Final Plat comment responses.pdf Markup Summary

FINAL PLAT  
COPPER CHASE AT STERLING RANCH  
FILING NO. 1  
JOB NO. 09-014  
DATE PREPARED: 04/27/2023  
DATE REVISED: 07/14/2023

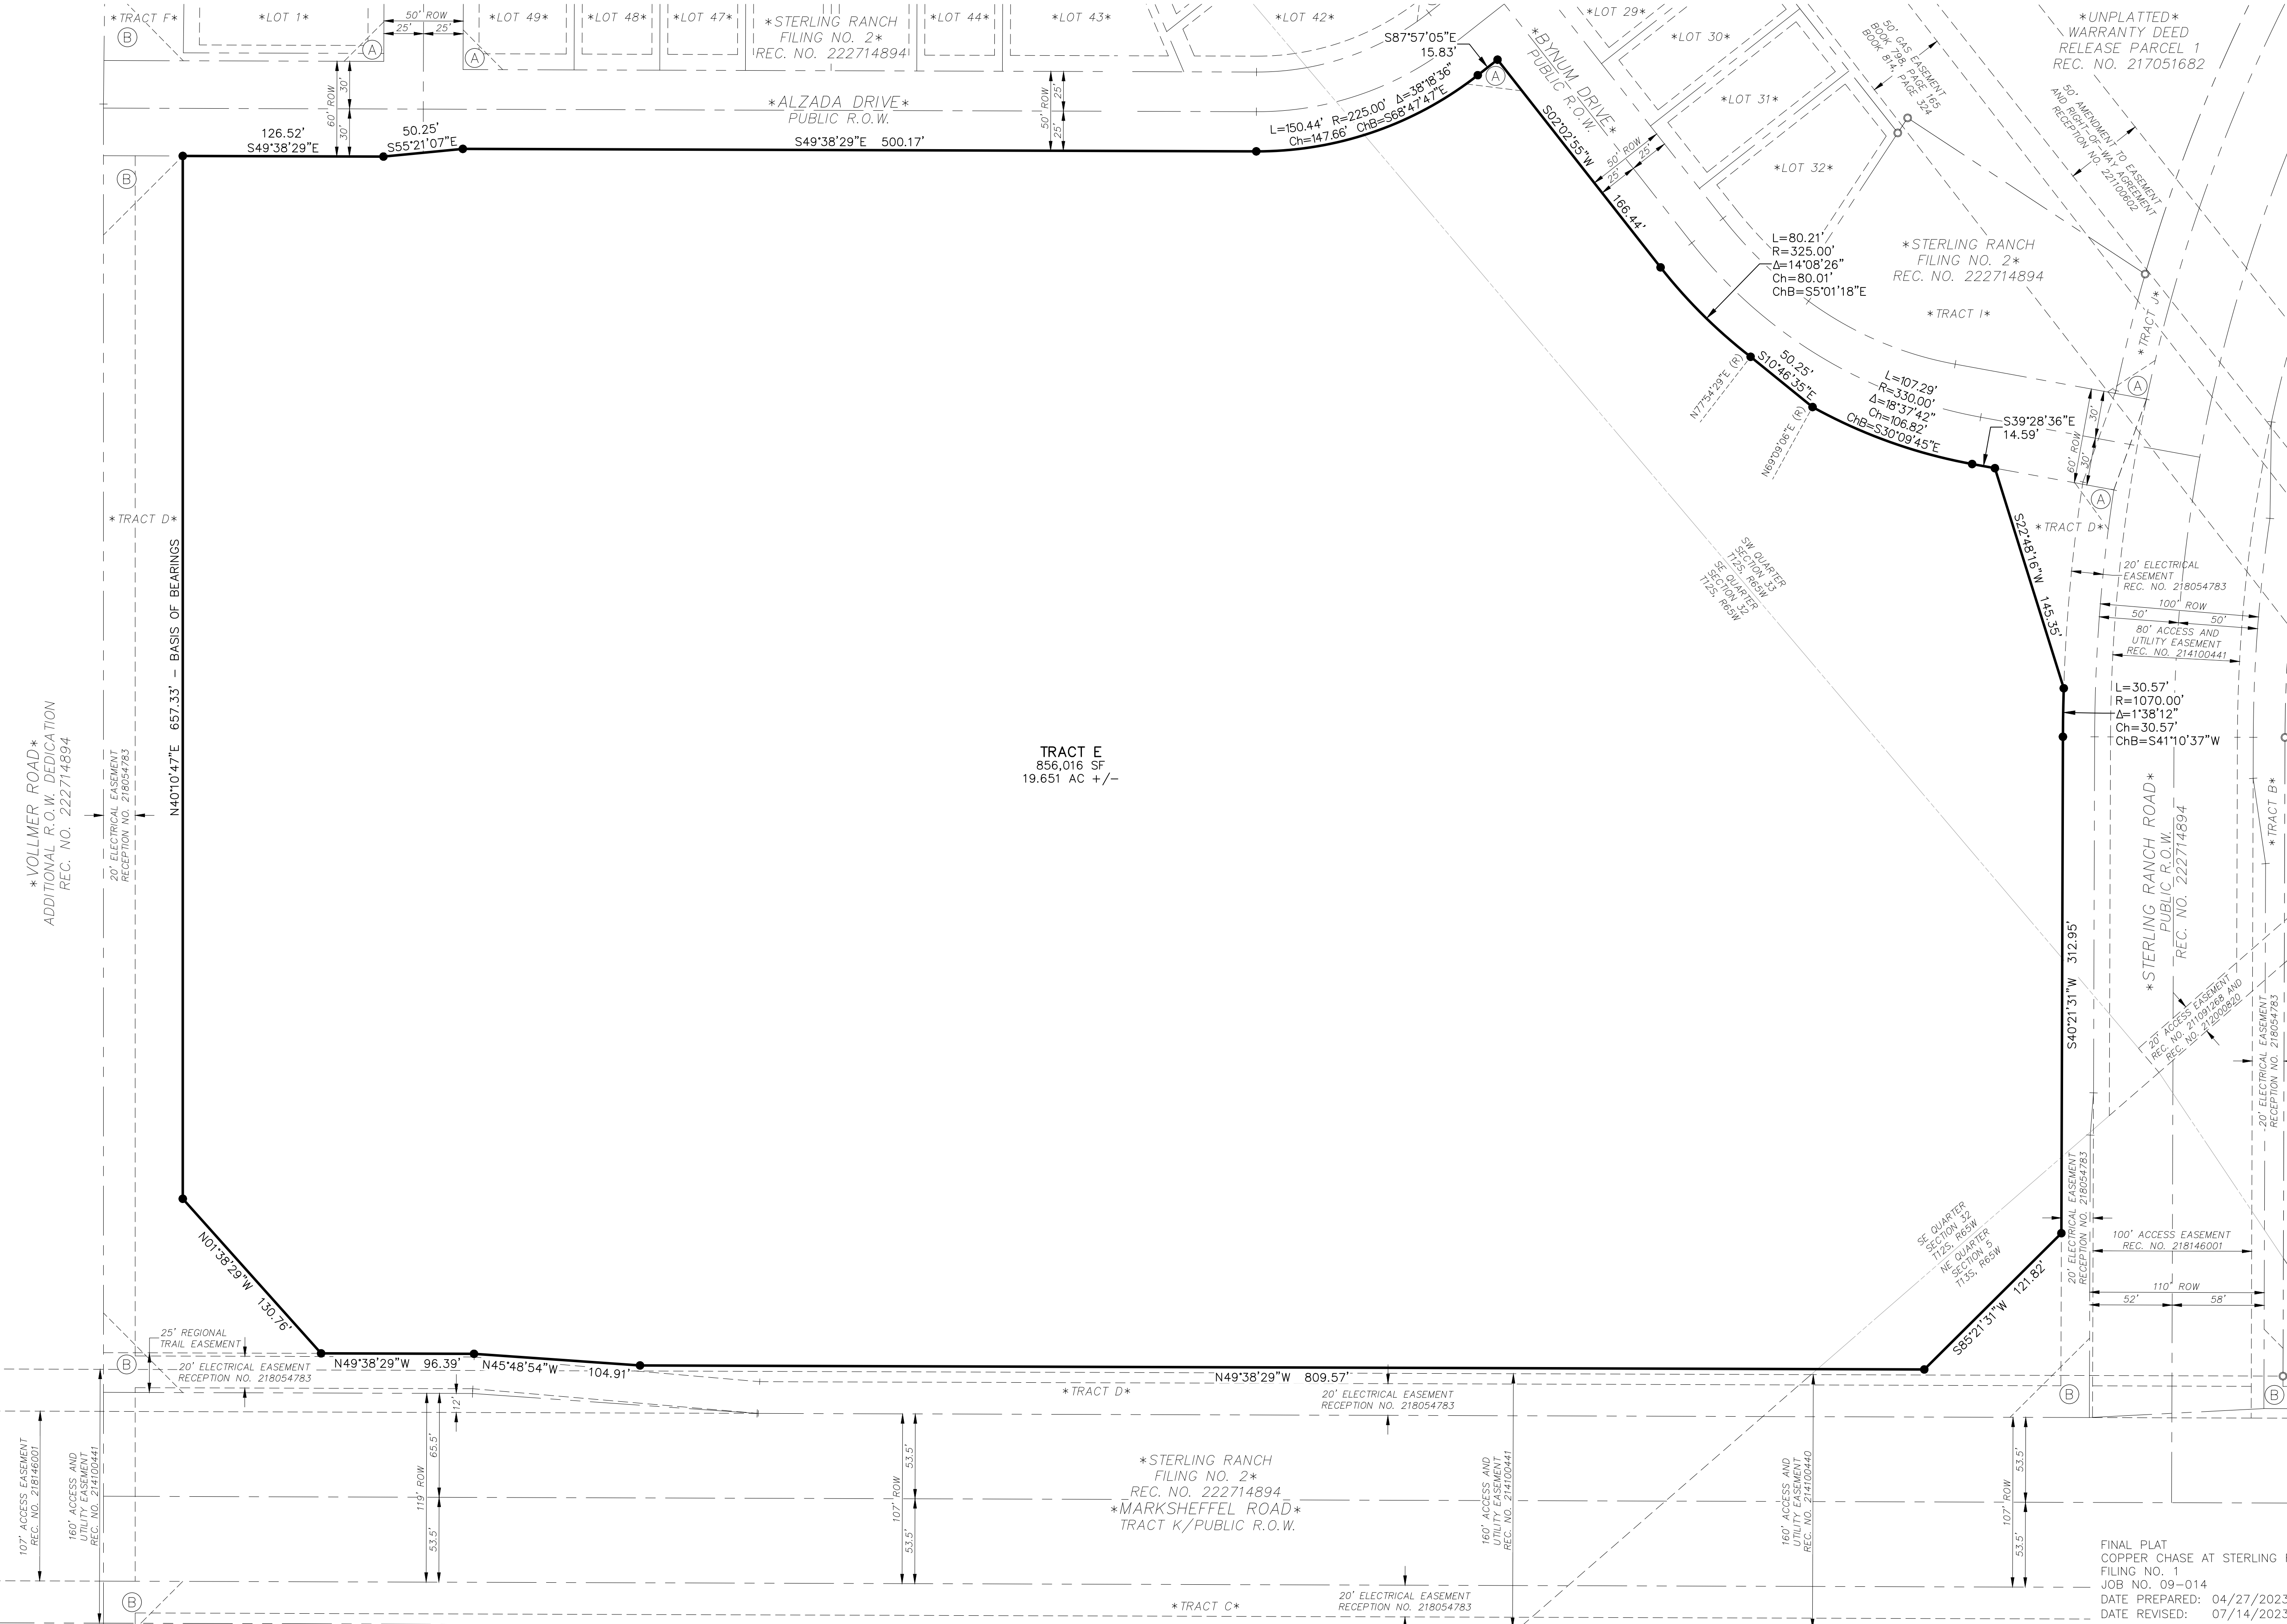
Subject: Callout
Page Label: Sheet 1 - Cover
Author: CDurham
Date: 6/26/2023 1:38:06 PM
Status:
Color: 
Layer:
Space:

or SF 23-016

Subject: Callout
Page Label: Sheet 1 - Cover
Author: dsdparsons
Date: 6/28/2023 1:42:58 PM
Status:
Color: ■
Layer:
Space:

its ok to have both PUDSP and SF

Subject: Callout
Page Label: Sheet 1 - Cover
Author: dsdparsons
Date: 6/28/2023 1:57:18 PM
Status:
Color: ■
Layer:
Space:

is this District maintaining any tracts, retaining walls?

Subject: Callout
Page Label: Sheet 1 - Cover
Author: dsdparsons
Date: 6/28/2023 1:57:58 PM
Status:
Color: ■
Layer:
Space:

FAWWA

Subject: Callout
Page Label: Sheet 1 - Cover
Author: dsdparsons
Date: 6/28/2023 1:58:27 PM
Status:
Color: ■
Layer:
Space:

remove fences

Subject: Callout
Page Label: Sheet 1 - Cover
Author: dsdparsons
Date: 6/28/2023 2:05:37 PM
Status:
Color: ■
Layer:
Space:

is this detention pond to be maintained by District verses HOA

Subject: Callout
Page Label: Sheet 1 - Cover
Author: dsdparsons
Date: 6/28/2023 2:07:30 PM
Status:
Color: ■
Layer:
Space:

identify the tracts that have sidewalks trails for use so it is clear to adj lots that a public trail will be provided by the developer

Subject: Callout
Page Label: Sheet 1 - Cover
Author: dsdparsons
Date: 6/28/2023 2:08:49 PM
Status:
Color: ■
Layer:
Space:

no basements are allowed (delete proposed this is the plat)

Subject: Callout
Page Label: Sheet 1 - Cover
Author: dsdparsons
Date: 6/28/2023 2:27:11 PM
Status:
Color: ■
Layer:
Space:

Add Trail

Subject: Callout
Page Label: Sheet 1 - Cover
Author: dsdparsons
Date: 6/28/2023 2:29:30 PM
Status:
Color: ■
Layer:
Space:

identify th installer and maintenance entity for the required retaining wall

Subject: Callout
Page Label: Sheet 1 - Cover
Author: dsdparsons
Date: 6/28/2023 2:30:05 PM
Status:
Color: ■
Layer:
Space:

to be maintained by the District (ties into storm system)

Subject: Callout
Page Label: Sheet 1 - Cover
Author: dsdparsons
Date: 6/28/2023 3:43:33 PM
Status:
Color: ■
Layer:
Space:

Add note identifying the plat is governed by the PUD zoning district , PCD file No _____ as recorded at _____

Subject: PID
Page Label: Sheet 1 - Cover
Author: dsdparsons
Date: 6/28/2023 2:03:47 PM
Status:
Color: ■
Layer:
Space:

Pursuant to Resolution _____, approved by the Board of Directors, El Paso County Public Improvement District __ and recorded in the records of the El Paso County Clerk and Recorder at Reception Number _____, the parcels within the platted boundaries of (subdivision) are included within the boundaries of the El Paso County Public Improvement District _ and as such is subject to applicable road impact fees and mill levy.

Subject: Road Impact
Page Label: Sheet 1 - Cover
Author: dsdparsons
Date: 6/28/2023 2:03:40 PM
Status:
Color: ■
Layer:
Space:

The Subdivider(s) agrees on behalf of him/herself and any developer or builder successors and assignees that Subdivider and/or said successors and assigns shall be required to pay traffic impact fees in accordance with the El Paso County Road Impact Fee Program Resolution (Resolution No. 16-454), or any amendments thereto, at or prior to the time of building permit submittals. The fee obligation, if not paid at final plat recording, shall be documented on all sales documents and on plat notes to ensure that a title search would find the fee obligation before sale of the property.

"SF 23-016" added to plat note.

"SF 23-016" added to plat note.

All tracts will be owned and maintained by the HOA; the proposed retaining wall has been eliminated from the design.

References to Sterling Ranch Metropolitan District No. 1 in plat notes 21 and 22 changed to Falcon Area Water and Wastewater Authority.

Reference to fences removed from note.

There is not a detention pond located on the site.

"Sidewalk" added as a use to all tracts except Tract C.

Basement restriction in the plat note reworded from "No basements below grade are proposed for this site" to "No basements are allowed for this site".

"TRAIL" added as track usage for all tracts except Tract C.

The retaining wall has been deleted from the plans and will therefore not require a plat note.

Verbiage added to plat note.

New plat note 27 added.

Verbiage added as new plat note 29.

Verbiage added as new plat note 28.

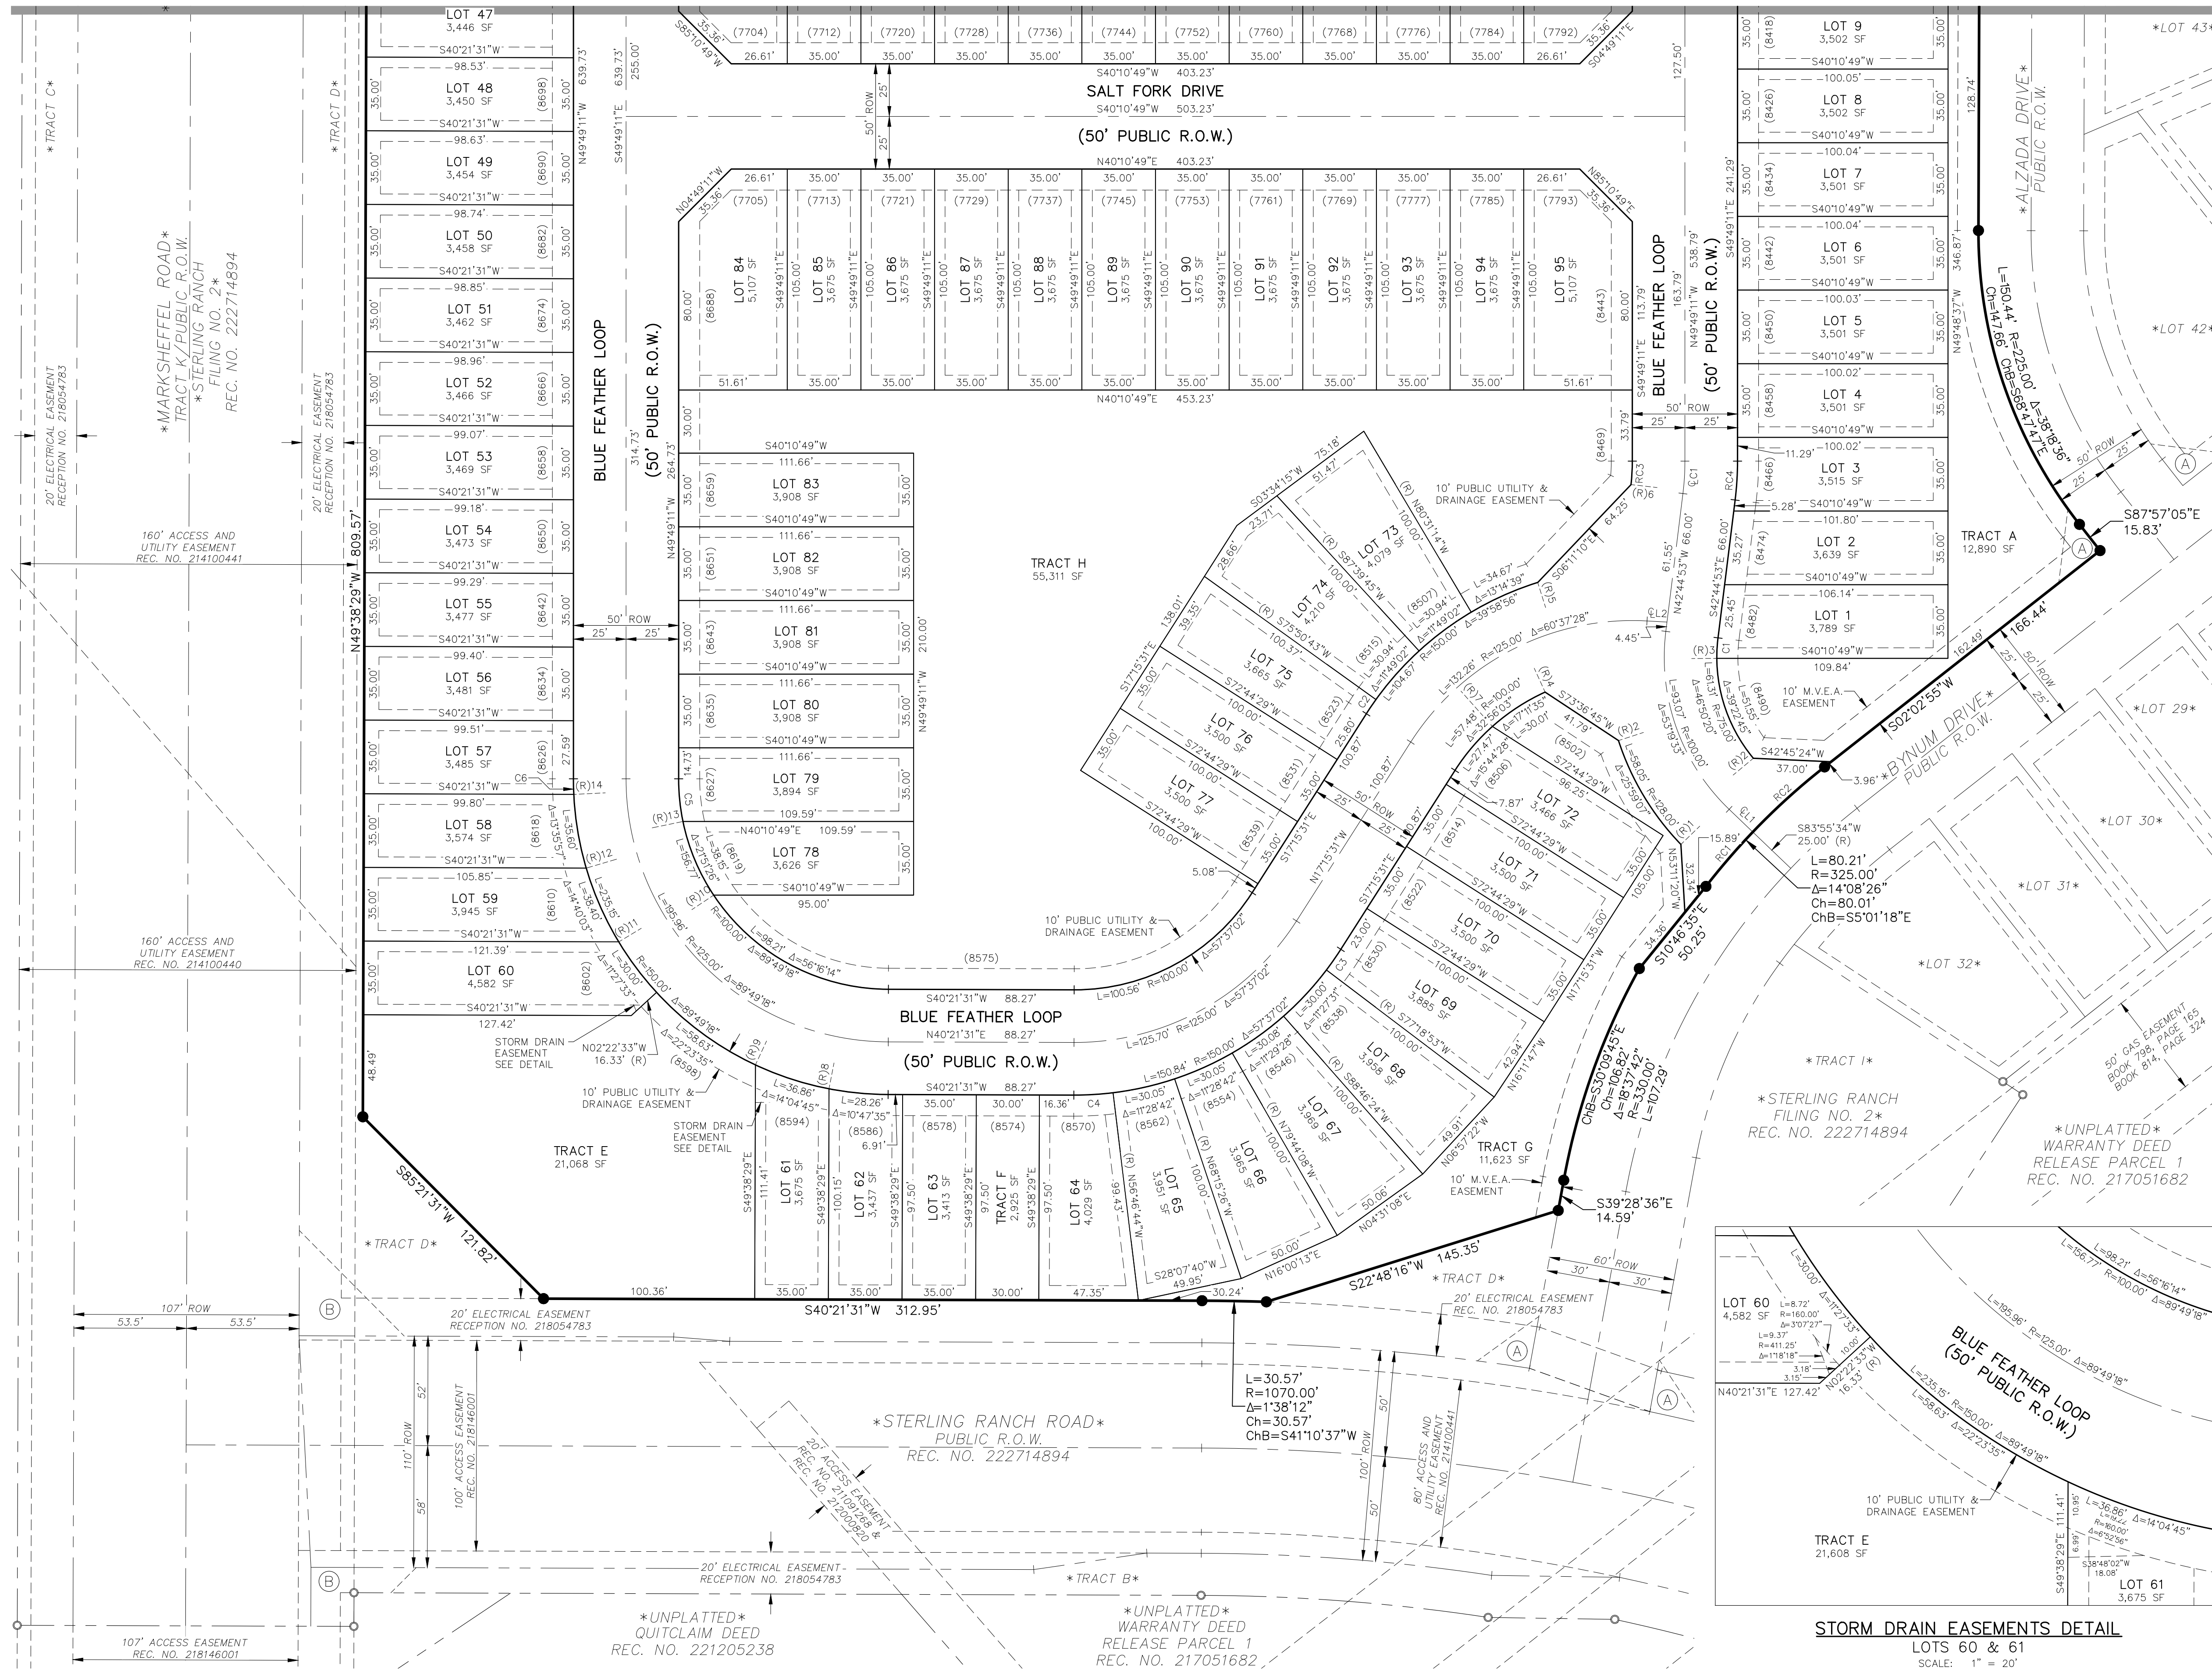
Subject: Callout
Page Label: Sheet 3 - As Replatted
Author: CDurham
Date: 6/27/2023 5:18:01 PM
Status:
Color: 
Layer:
Space:

2 separate curves labeled as C6. Please change one to a different label

Subject: Callout
Page Label: Sheet 3 - As Replatted
Author: CDurham
Date: 6/27/2023 5:19:27 PM
Status:
Color: 
Layer:
Space:

Missing C5 in curve table. Please add

Subject: Callout
Page Label: Sheet 3 - As Replatted
Author: CDurham
Date: 6/28/2023 11:16:37 AM
Status:
Color: ■
Layer:
Space:

Deviation needed for tangent length between broken back curve (ECM 2.3.3.F.3). Min length for local roadways is 200'

Subject: Callout
Page Label: Sheet 3 - As Replatted
Author: CDurham
Date: 6/28/2023 11:18:50 AM
Status:
Color: ■
Layer:
Space:

Chamfer area at intersections should be ROW, not a PIE.

Duplicate curve labels eliminated. Note that curve numbers have changed due to changes made to lots and tracts when areas within sight triangle/public improvement easements were added to the rights-of-ways.

Missing curve information for "C5" added to the Curve Table. Note that curve numbers have changed due to changes made to lots and tracts when areas within sight triangle/public improvement easements were added to the rights-of-ways.

A deviation has been submitted with the Copper Chase PUD, SP-222.

Lots, tracts, and rights-of-way modified to eliminate public improvement easements at intersections.
